CITY OF ALBUQUERQUE

Re: 3901 Masthead NE
Request for Certificate of Occupancy- Transportation Development
Engineer's/Architect's Stamp dated 08-31-16 (D17-D095)
Certification dated 01-19-16

Ref: **TCL Certification**
3901 Masthead, NE

RE: 3901 Masthead St. NE
Grading & Drainage Plan
Engineer's Stamp Date 9-26-2016 (File: D17D095)

GRADING PLAN - WEST DRIVEWAY

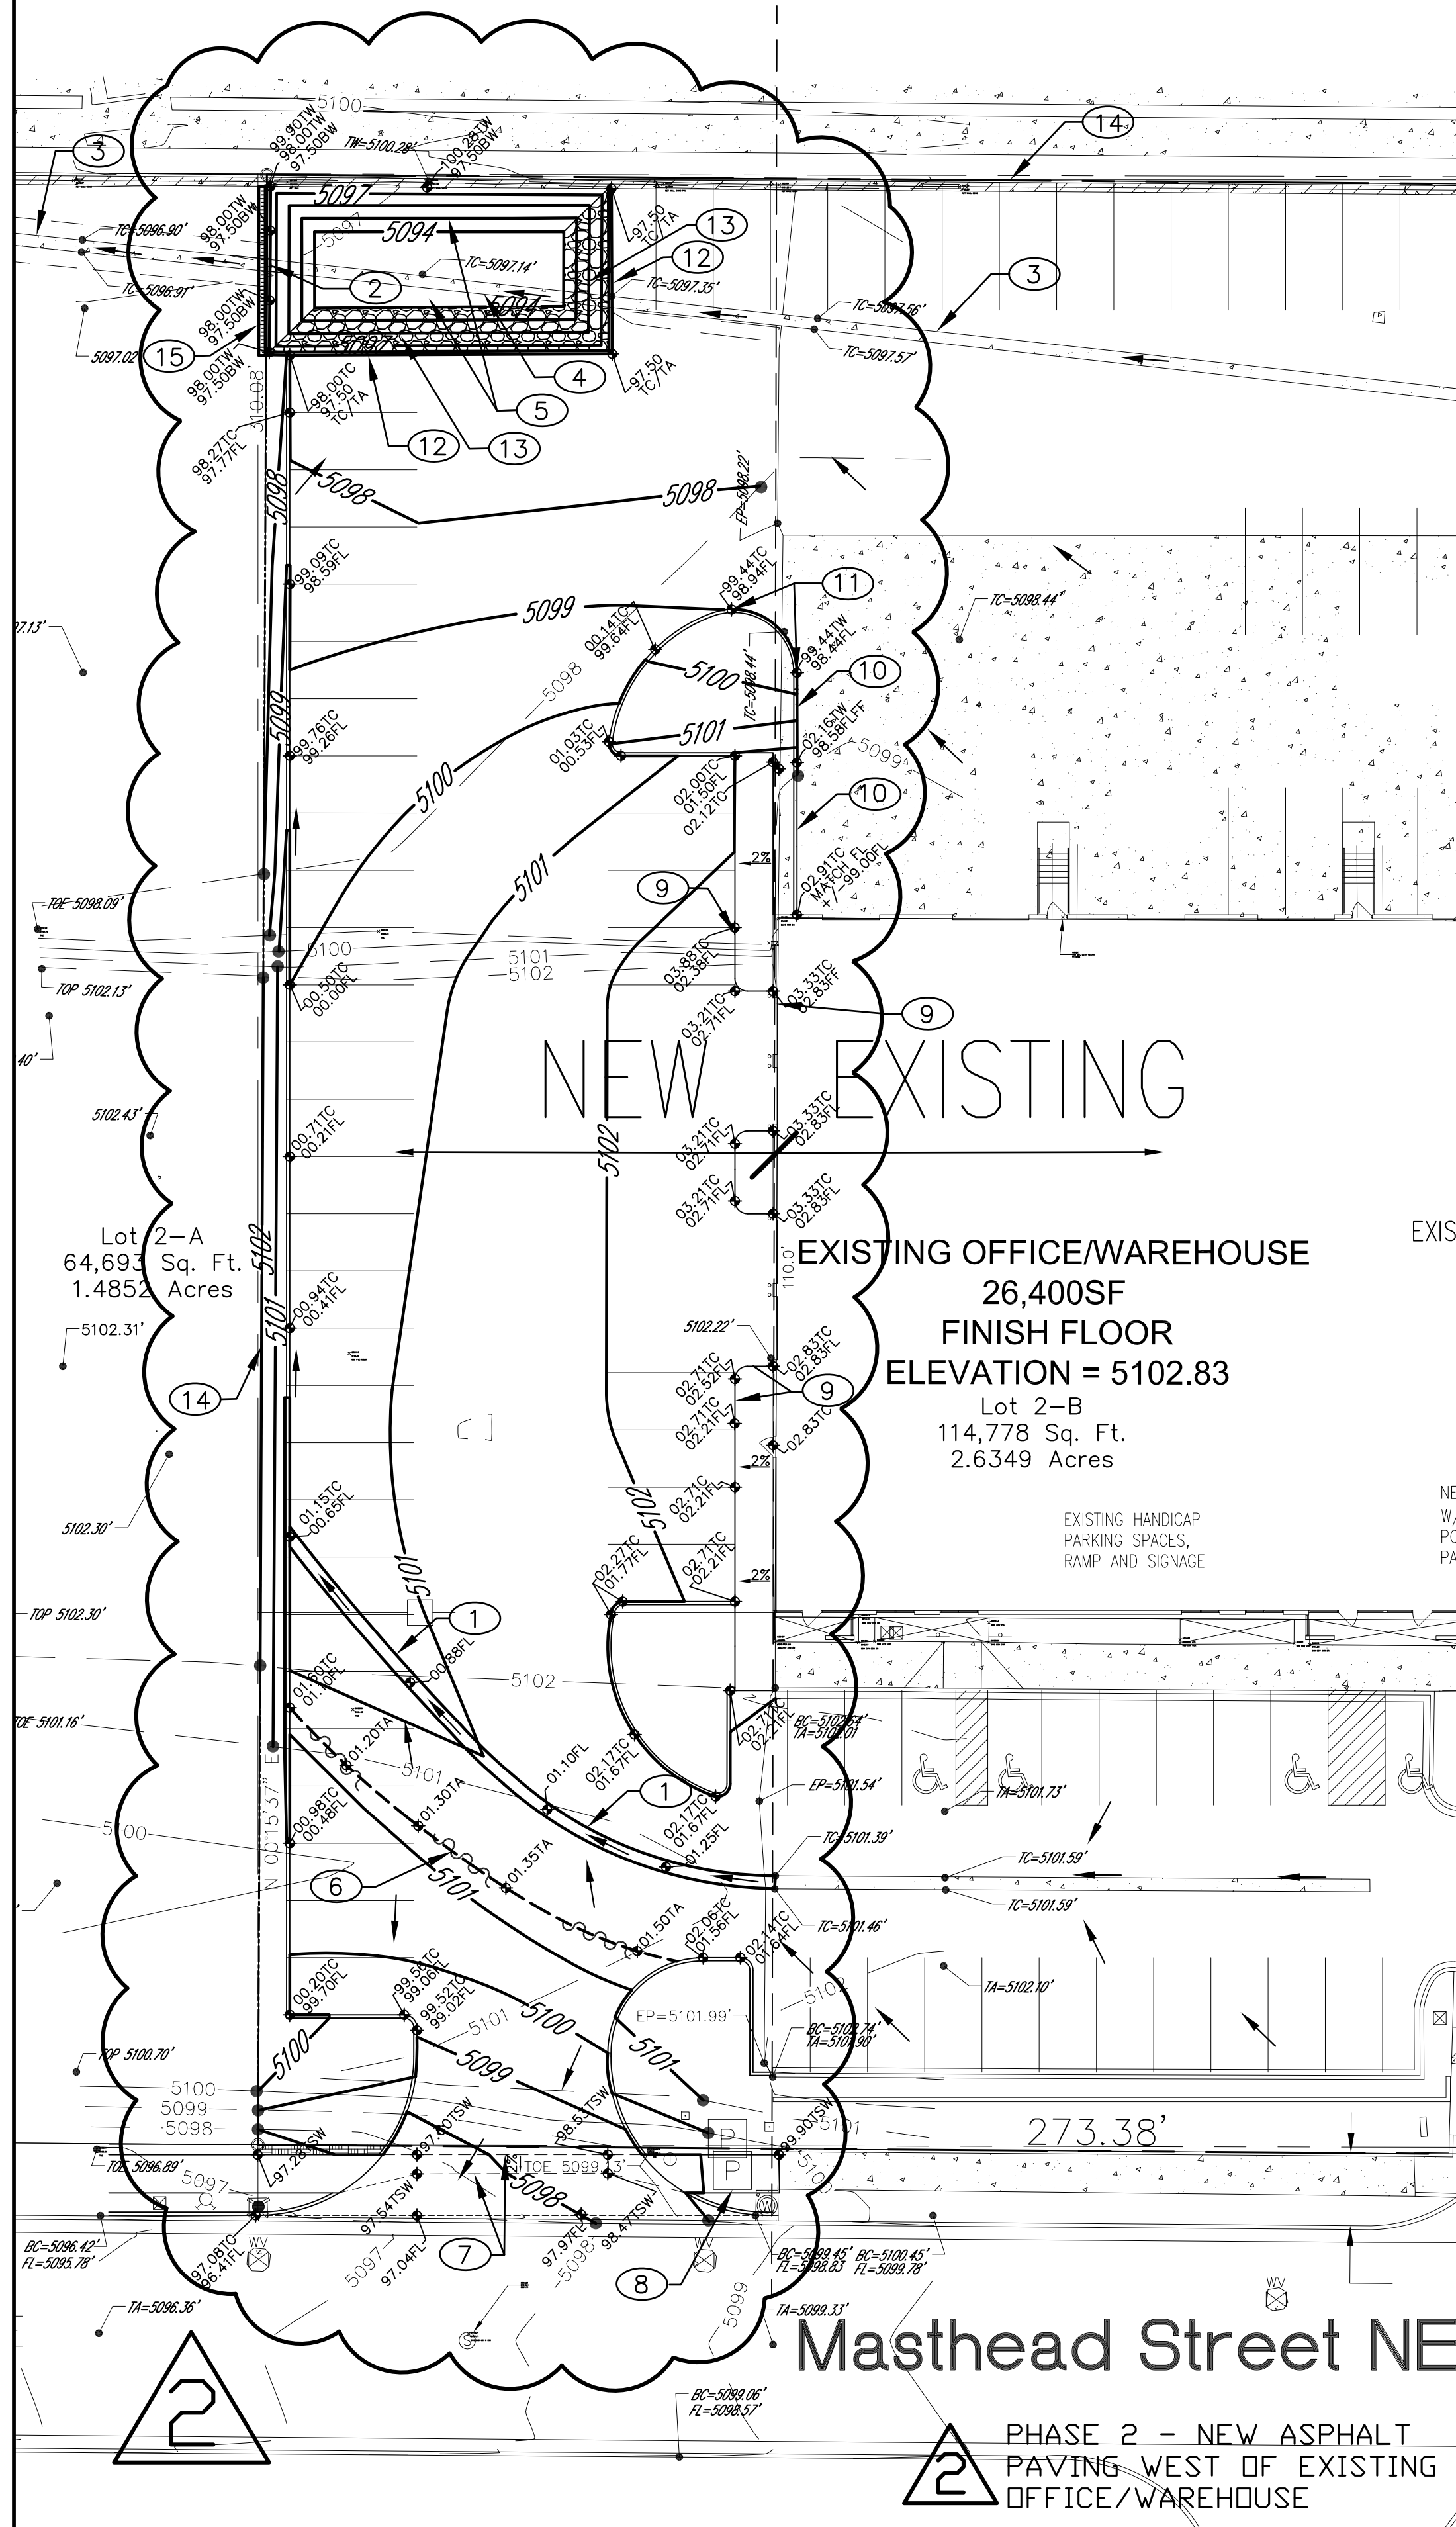
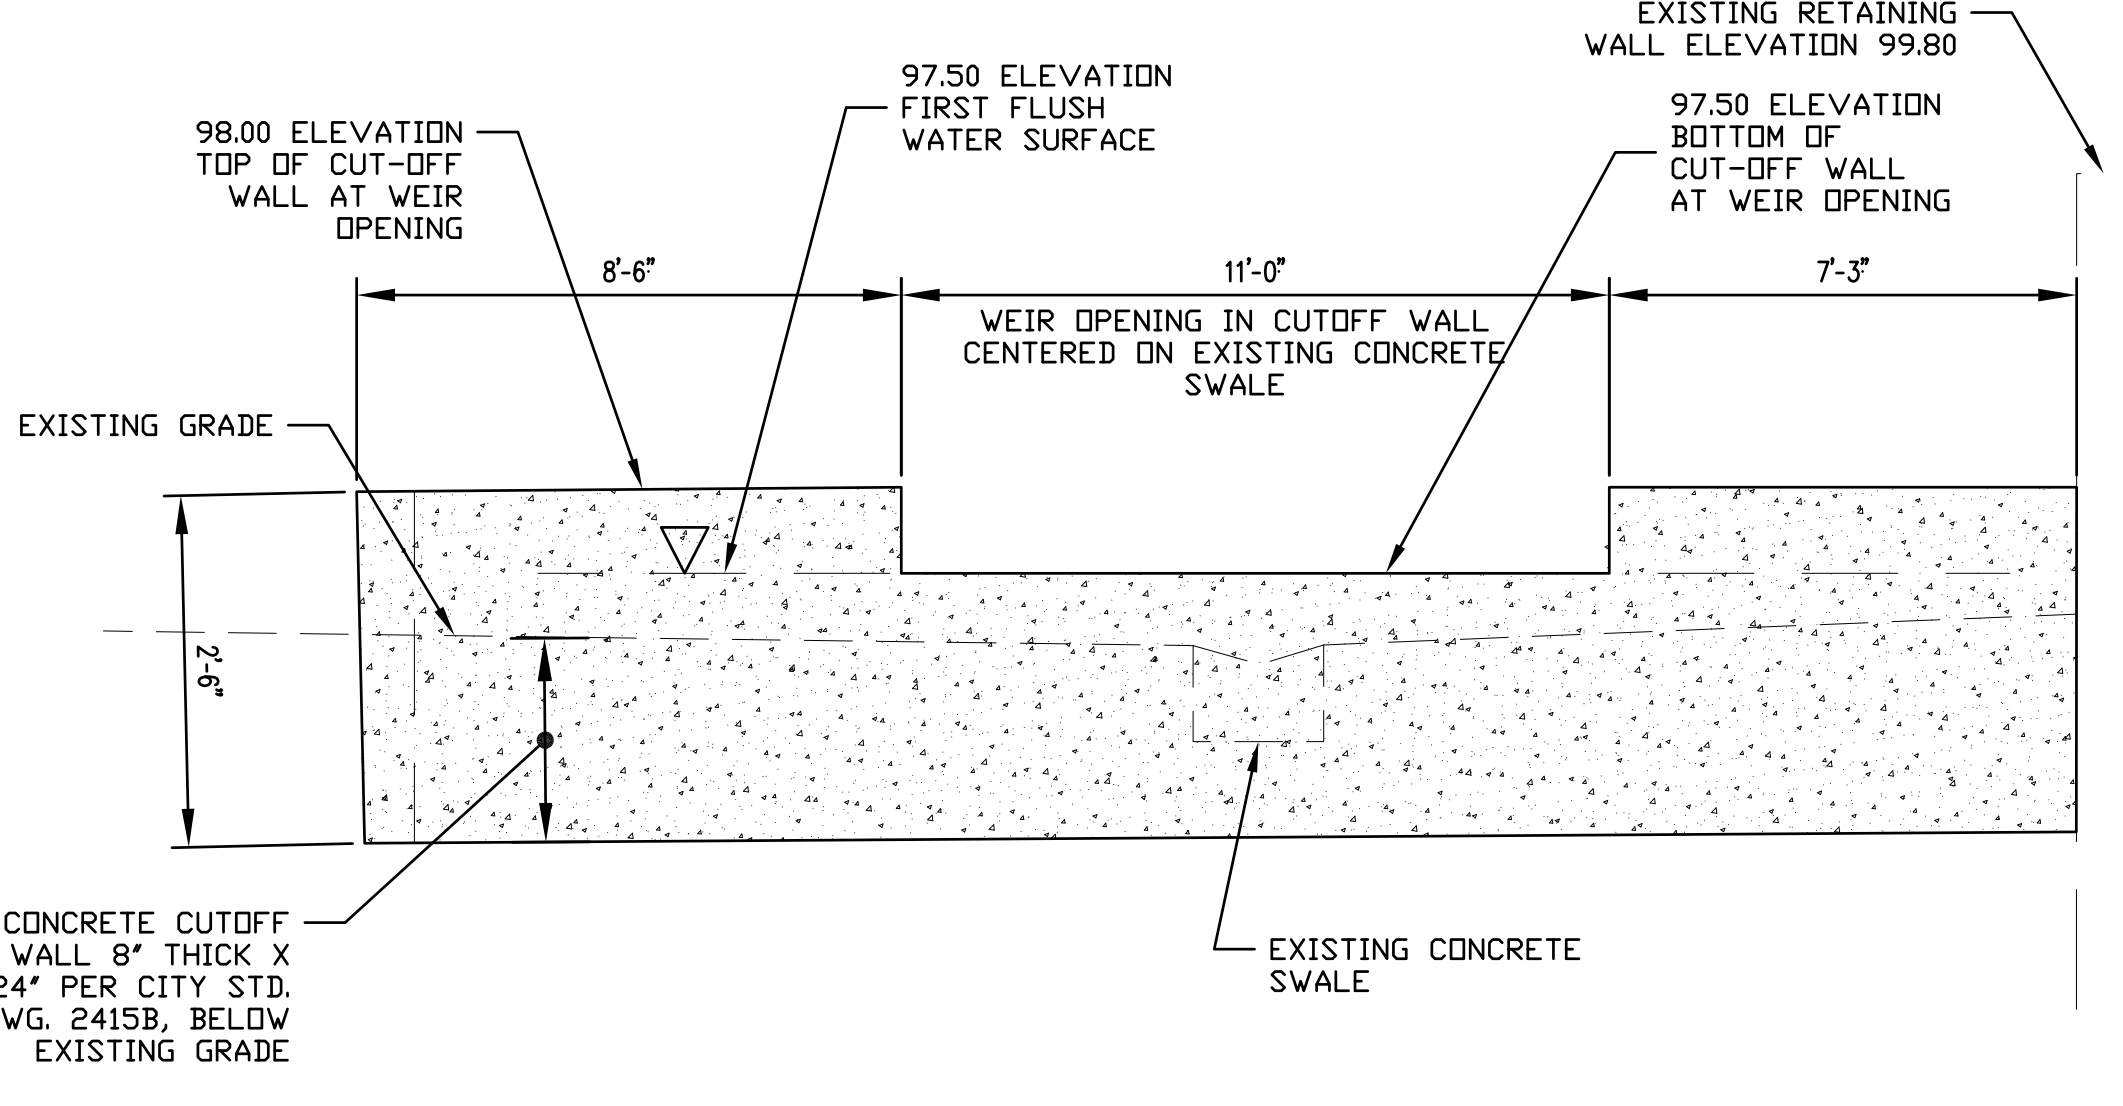
- First flush pond needs to be pervious so that pollutants infiltrate. (NOW INCLUDED IN PLAN)
- You can calculate the first flush volume using 0.34"
(NOW INCLUDED IN PLAN)

- Show the property lines (NOW INCLUDED IN PLAN)
- You are showing grading on the adjacent property, do you have an agreement?
(ADJUSTED GRADING TO NOT GRADE ON ADJACENT PROPERTY)

- I recommend increasing the width of the landscape strip along west property line, and create a bio-swale with check dams to get additional first flush volume. The Alley gutter can then discharge into the bioswale via a curb cut.
(SLOPE TO STEEP IN LANDSCAPE STRIP TO ACCOMMODATE SUFFICIENT VOLUME, INCLUDED 3 PARKING SPACES TO ACCOMMODATE)

- After discussing it with Curtis, he is not going to require a full blown ESC plan since this site is less than a half an acre and implementation is simple. Implementation is to place a wattle or mulch

sock across the 2' wide alley gutter wet of the disturbed area. Show on the plan using a build note. (ADDED WADDLE WITH NOTE)

- Keyed Note 5 states that pond side slopes are at 2:1. It infers that all sides are at 2:1, but rip-rap is only shown on 2 sides. All slopes steeper than 3:1 require rip-rap per DPM. Prior to C.O. rip-rap should be on all sides of pond.
- ~~Edit the leader of Keyed Note 3. It is not pointing to the location of the weir, which is on west side of pond.~~ *RIH 9/27/16*
- Edit Keyed Note 15 to ensure the ESC BMP is implemented before /during construction, but not required once it is built. Please ensure contractor implements the BMP.

Made the corrections per your attached comments:

1. Changed north and west slope to 3:1, we still have sufficient volume
2. Note 3 points to the existing concrete swale west of the subject property, note 2 is the weir.
3. Revised Note 15 regarding ESC BMP.

NORTH  
 SITE DEVELOPMENT  
 PLAN FOR  
 BUILDING PERMIT  
 JUNE 09, 2005 SCALE: 1" = 30' (U.N.O.)

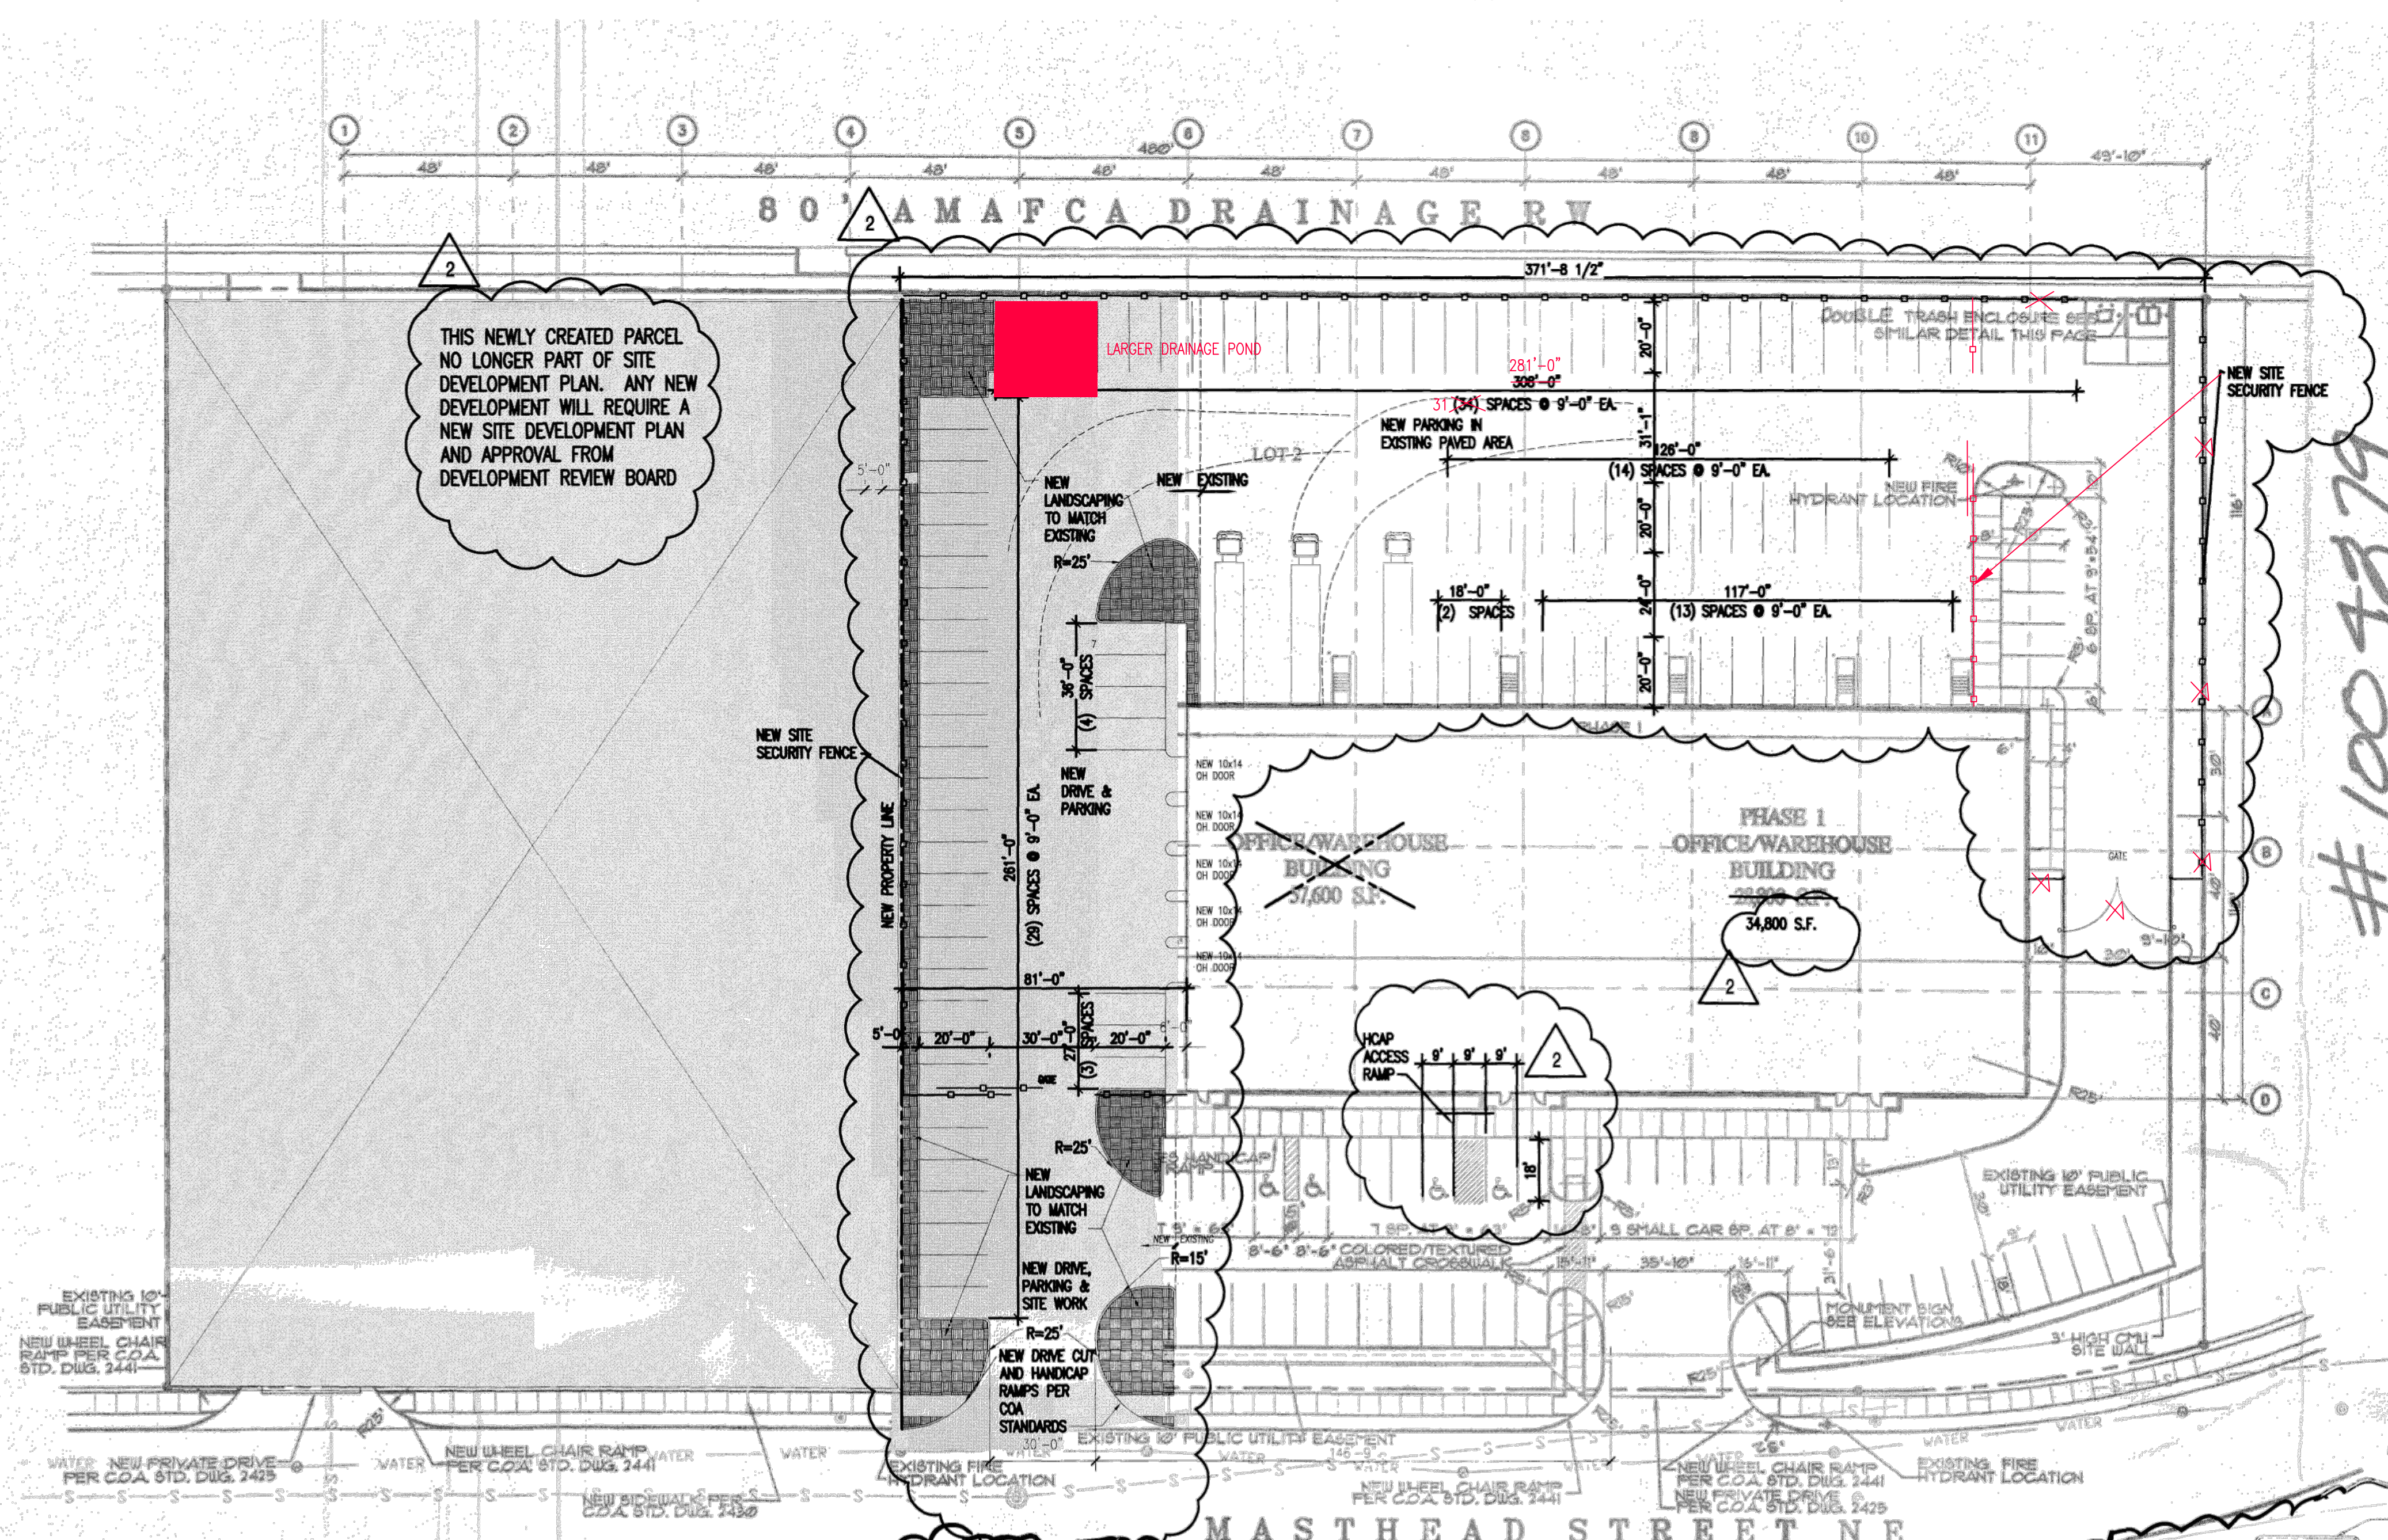
- Truncated domes (detectable warning surfaces) need to extend the full width of the curb ramp. The truncated domes at the West entrance are improperly installed.

- The plan call for the curb ramps at the East entrance to be reconstructed. This will require the ramps to meet current ADA standards and have truncated domes.

- The van accessible handicap parking at the front entrance needs to have the ADA curb ramp to allow access to the building. ADA accessible pedestrian pathway should not be placed behind parking space or adjacent to a vehicular way. Vehicle and pedestrian/wheel chair conflicts should be avoided as much as possible.

- The parallel parking stalls on the east side of the lot are not indicated on the plans. The added parking spots prevent two-way traffic, by reducing the aisle width below 24 feet.

- The parking spot between the West gate and the key pad should be striped to prevent parking in that spot. This will reduce vehicle conflicts.
